Recommendation Report for Planning Permission for Works or Extension to a Dwelling

REF NO: BN/158/20/HH

LOCATION: Deep End
Lake Lane
Barnham
PO22 0AD

PROPOSAL: Ground floor front extension and porch & first floor side extension.

DRG 2.

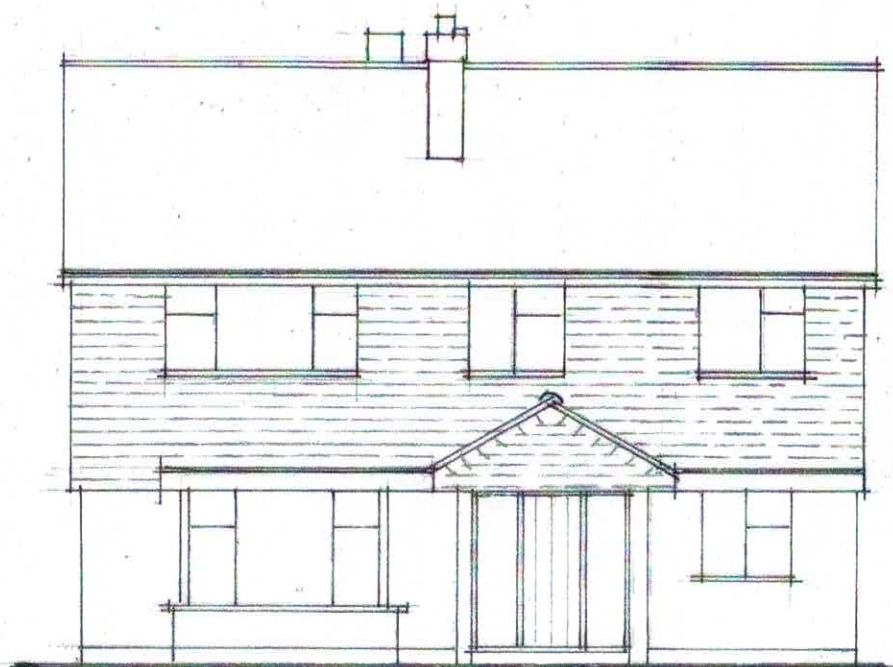
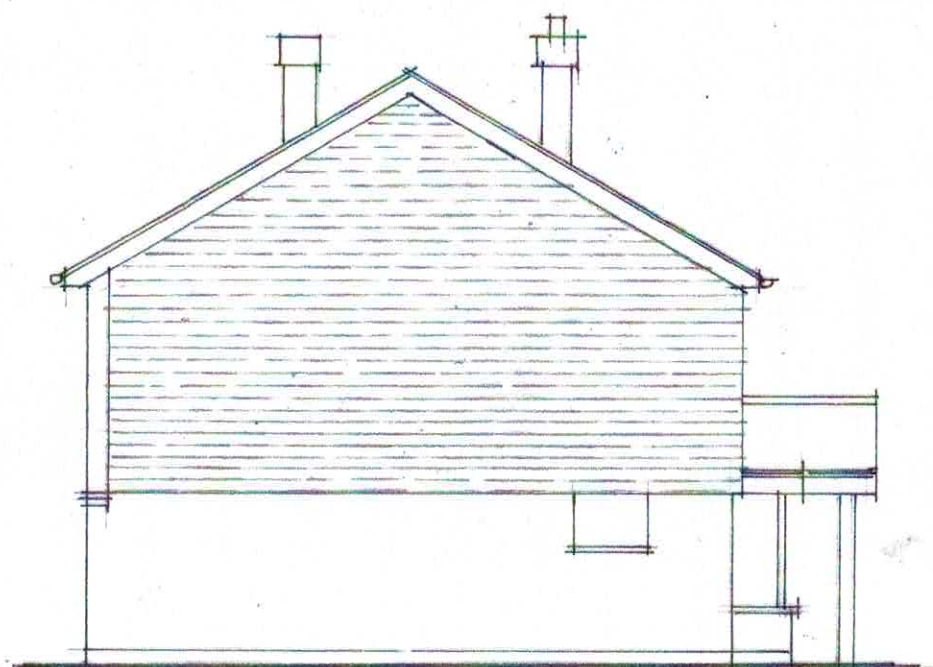
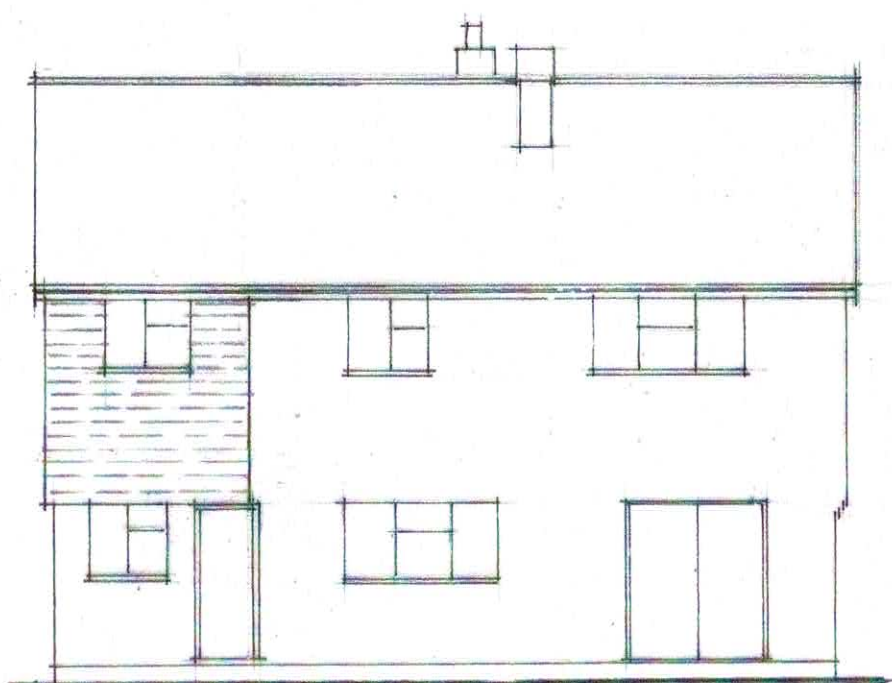
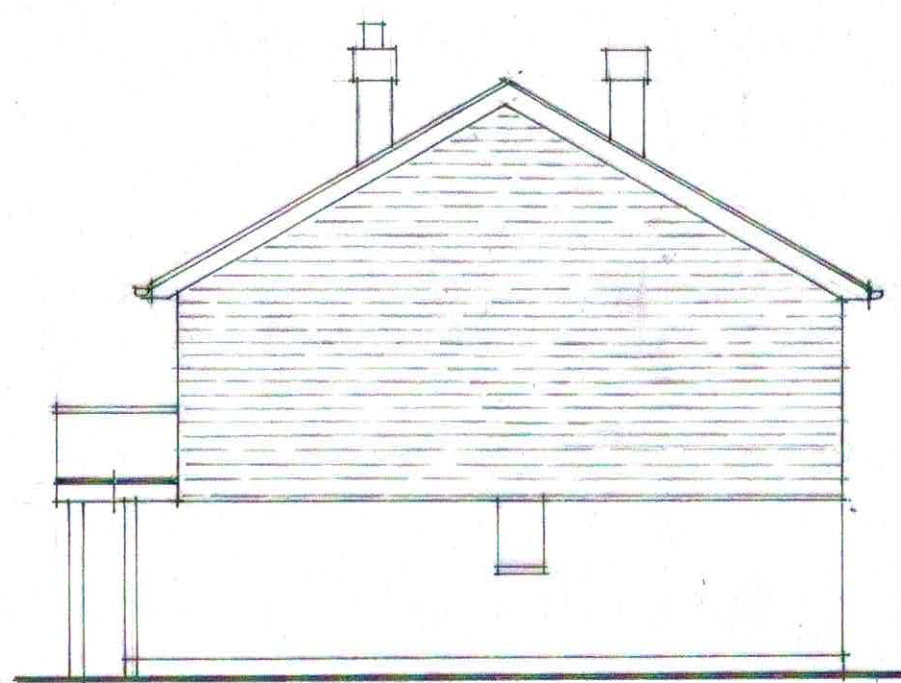
The development projects from the South Western wall of the host dwelling, and due to the reasonably open nature of the front boundary on that side of the host dwelling there will be some views of the extension available from the public realm. Whilst there is a change in appearance of the dwelling, it is not considered to be so significant as to justify refusal of the application. The first floor extension is not considered to appear subservient to the host dwelling due to the ridge height matching that of the existing dwelling. However, this itself is not considered enough to warrant refusal of the application. The character of the area has no set spatial pattern with a wide MIX of designs on display along Lake Lane allowing the development to have a limited impact upon the character of the area. The use of materials to match the dwelling is considered to allow the proposal to appear greater integration with the dwelling. Whilst the proposal does result in a change to the roof shape, it is not considered to have any harmful impact on the spatial pattern of the locality.

The front extension will be visible from the street scene due to the siting and scale. However, resultant of the extensions relationship with the host dwelling in terms of design, the proposal is considered to be subservient additions to the host dwelling on the whole. The area is not deemed to have a set spatial pattern, allowing the proposal to not drastically alter the character of the area.

Therefore, whilst the proposal will result in a change to the appearance of the host dwelling within the public realm, it is not considered to be so significant as to prescribe refusal of the application. The proposal is considered to be in accordance with D DM1, D DM4(a) and (b) of the Arun Local Plan.

The Arun Design Guide explains in section M that alterations to a dwellinghouse should compliment the character and appearance of the building and wider landscape. The scheme is considered to be well integrated which is achieved through the simple design and unobtrusive form. As well as this the use of the continuation of the existing pitch roof allows the proposal to further follow the design guide which specifies to the front of properties proposals should avoid large, flat topped alterations.

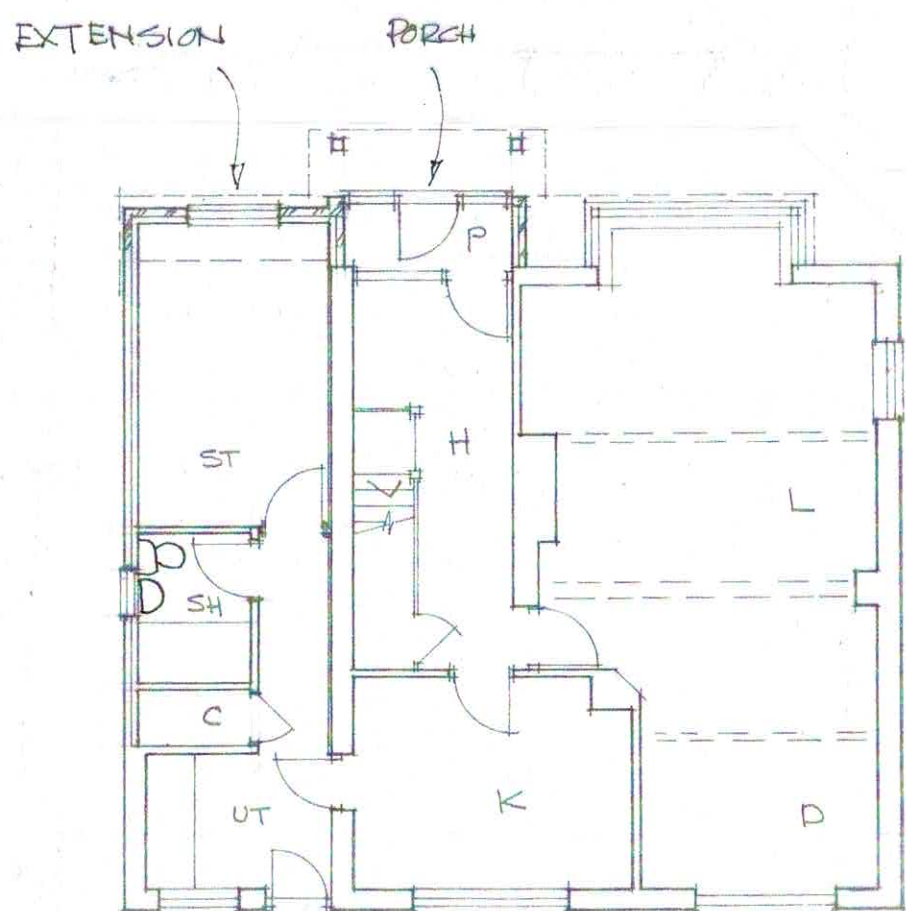
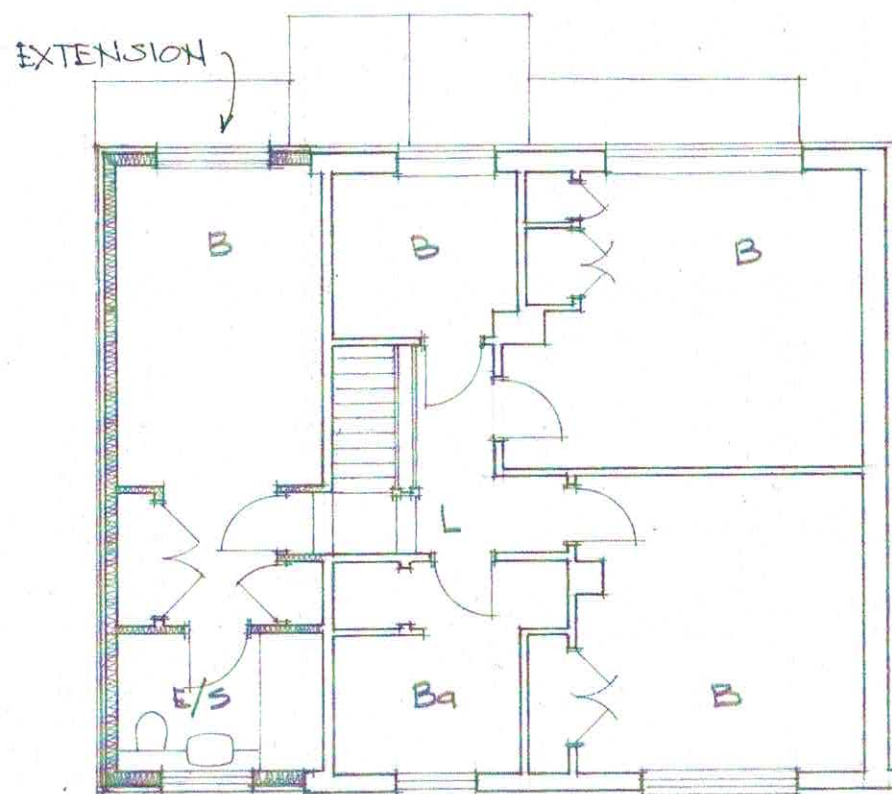
upon occupiers of neighbouring dwellings. This is due to the siting of the proposal leaving 0.9m to the boundary and 2.3m to the closest section of the neighbouring property, this is considered to be sufficient enough to allow for the overshadowing impact to be reduced sufficiently. With regard to loss of privacy to occupiers of neighbouring dwellings, there are no openings of which provide any views of which are currently unavailable from the host dwelling at current.

The extension and porch to the front is not considered to result in any harmful impact upon the residential amenities of nearby dwellings. This is as a result of the siting of the proposed development as being away from the dwellings in the area, and its scale. With regard to potential for loss of privacy, the proposal is not considered to introduce any views of which are unavailable from the application site at current.
